Rezoning Transportation Analysis

Petition Number: #2022-170

Revision Log:

NOT FOR CONSTRUCTION
 FILE NUMBER:
 8201-14
 AUGUST 25, 2022
RZ2-2

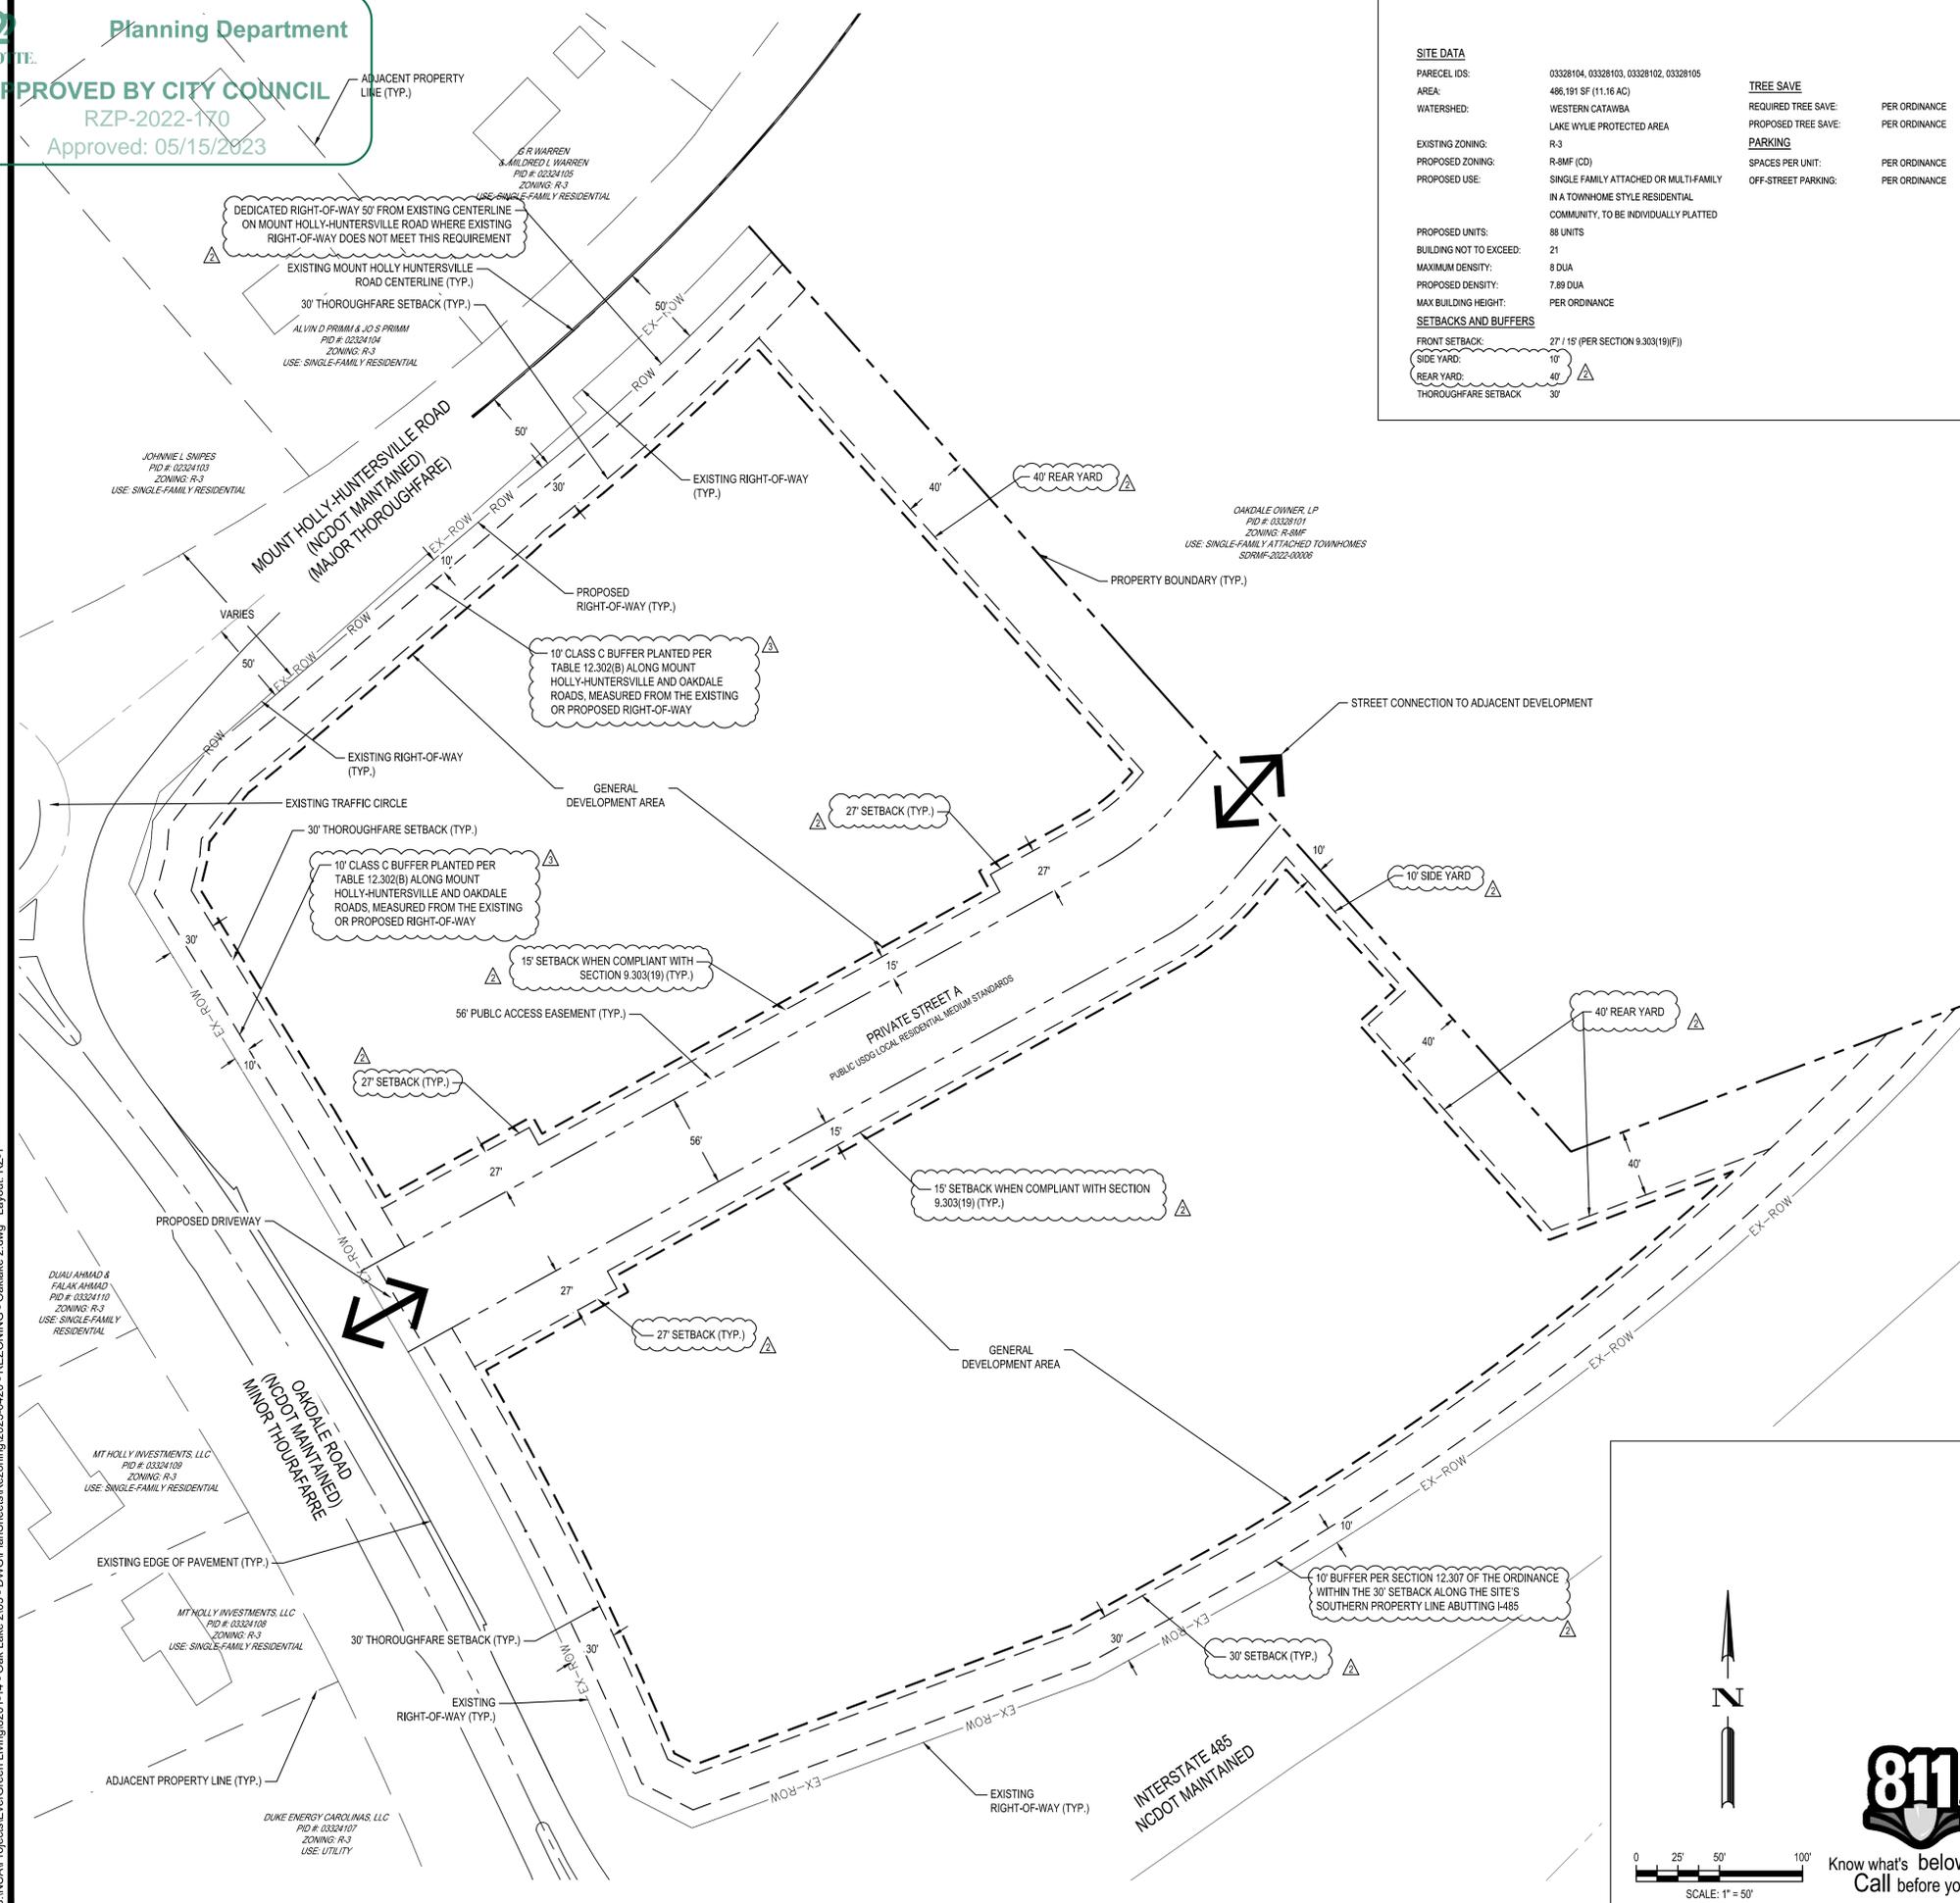
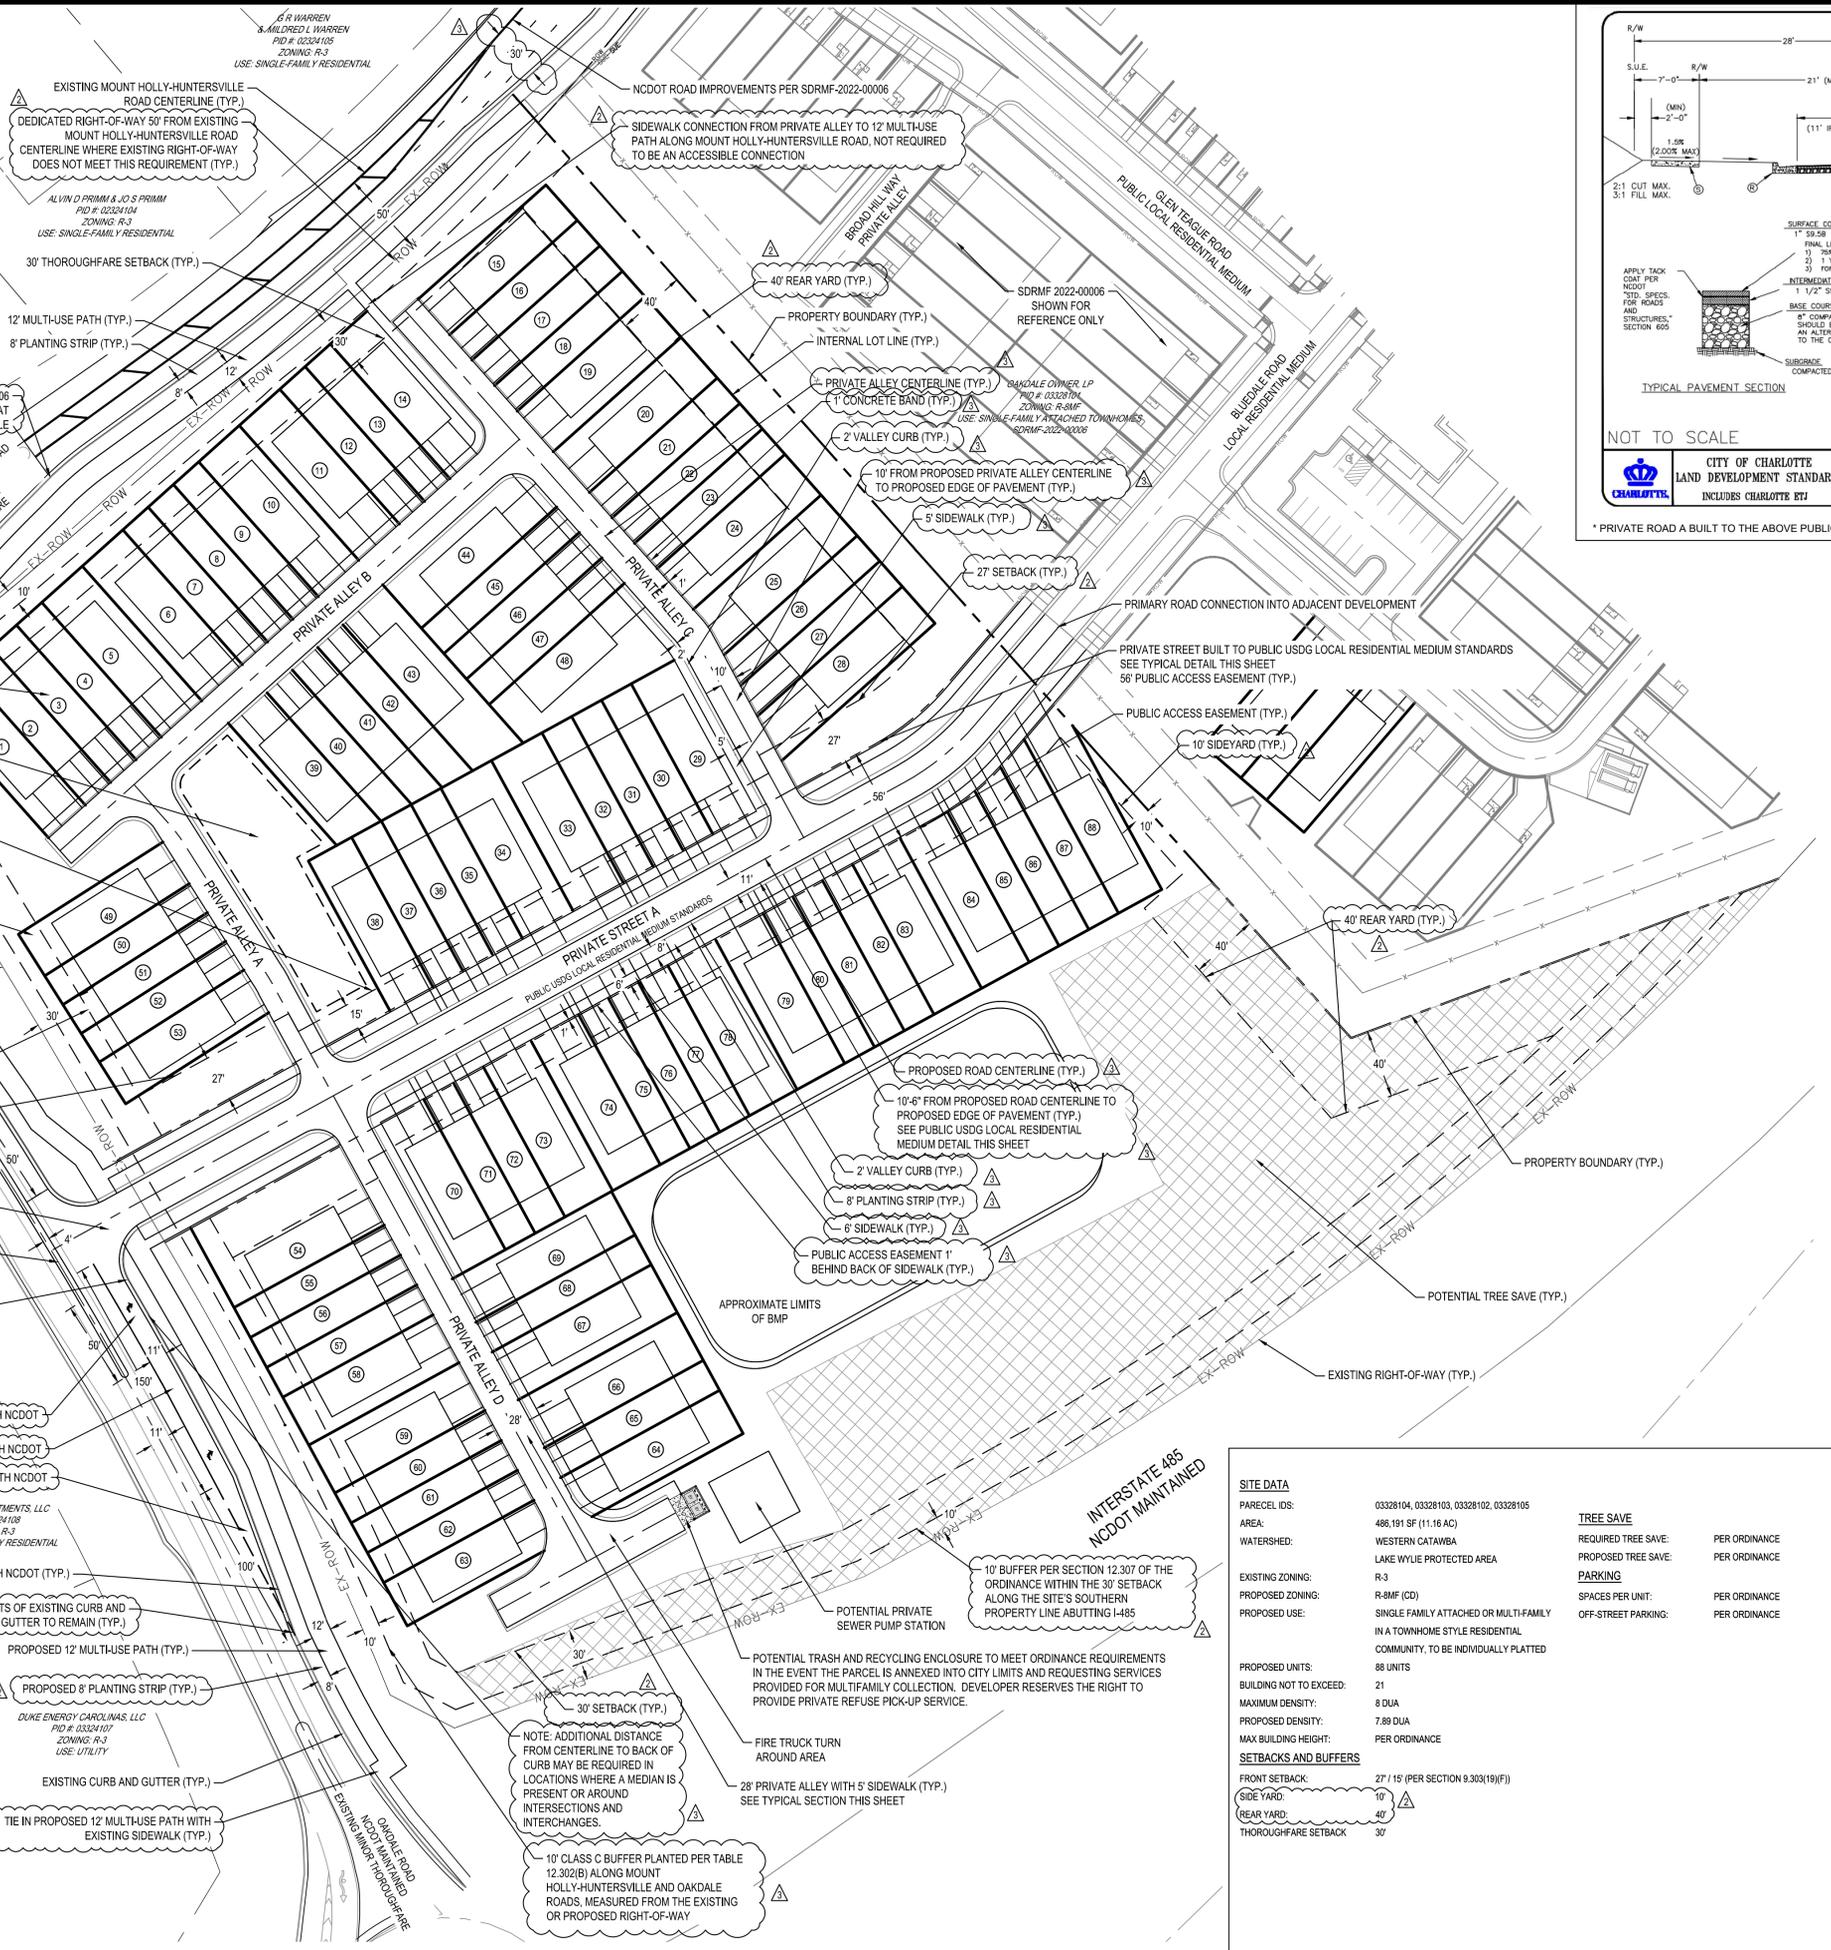
a. ~~**Mt Holly Huntersville Road:** Location of curb and gutter to be moved to 30 feet from roadway centerline to accommodate the Charlotte Streets Map with a roadway typical section of 4+ Avenue, Shared Use Path.~~

b. ~~**Oakdale Drive:** Location of curb and gutter to be moved to 19 feet from the roadway centerline to accommodate the Charlotte Streets Map with a roadway typical section of 2+ Avenue, Shared Use Path.~~

~~Label and dimension the curb and gutter from the centerline for each road on the site plan.~~

3. ~~Revise site plan and conditional note(s) to commit to dedicate 50 feet of right of way from the Mt Holly Huntersville Road centerline. The site plan shall label and dimension the right of way from the road centerline.~~

5. ~~Revise site plan and conditional note(s) to commit to restrict Oakdale Drive site access to right in right out by constructing a median that does not restrict access to neighboring parcels in coordination with NCDOT. Median shall extend 50 feet past the site entrance in either direction.~~

6. ~~Revise site plan and conditional note(s) to commit to widening Oakdale Drive enough to construct a right turn lane into the site with 100 feet of storage in coordination with NCDOT. Site plan shall label and dimension right turn lane. Add a conditional note committing to constructing the right turn lane.~~

7. ~~Revise site plan and conditional note(s) to commit to construct bicycle facilities by installing a 12' multi-use path on Oakdale Road to meet the Council adopted Charlotte BIKES Policy. Multi-use paths maintained by the City shall meet ADA/PROWAG requirements. This also matches Charlotte streetscape map.~~

8. **Outstanding Comment from 02-22-23:** ~~Revise site plan by dimensioning and labeling the internal street infrastructure including curb line, sidewalk, planting strip and Right of way.~~

13. **New Comment 03-23-23:** ~~Remove driveways from CDOT 50'x50' sight triangles areas connecting to Street A.~~
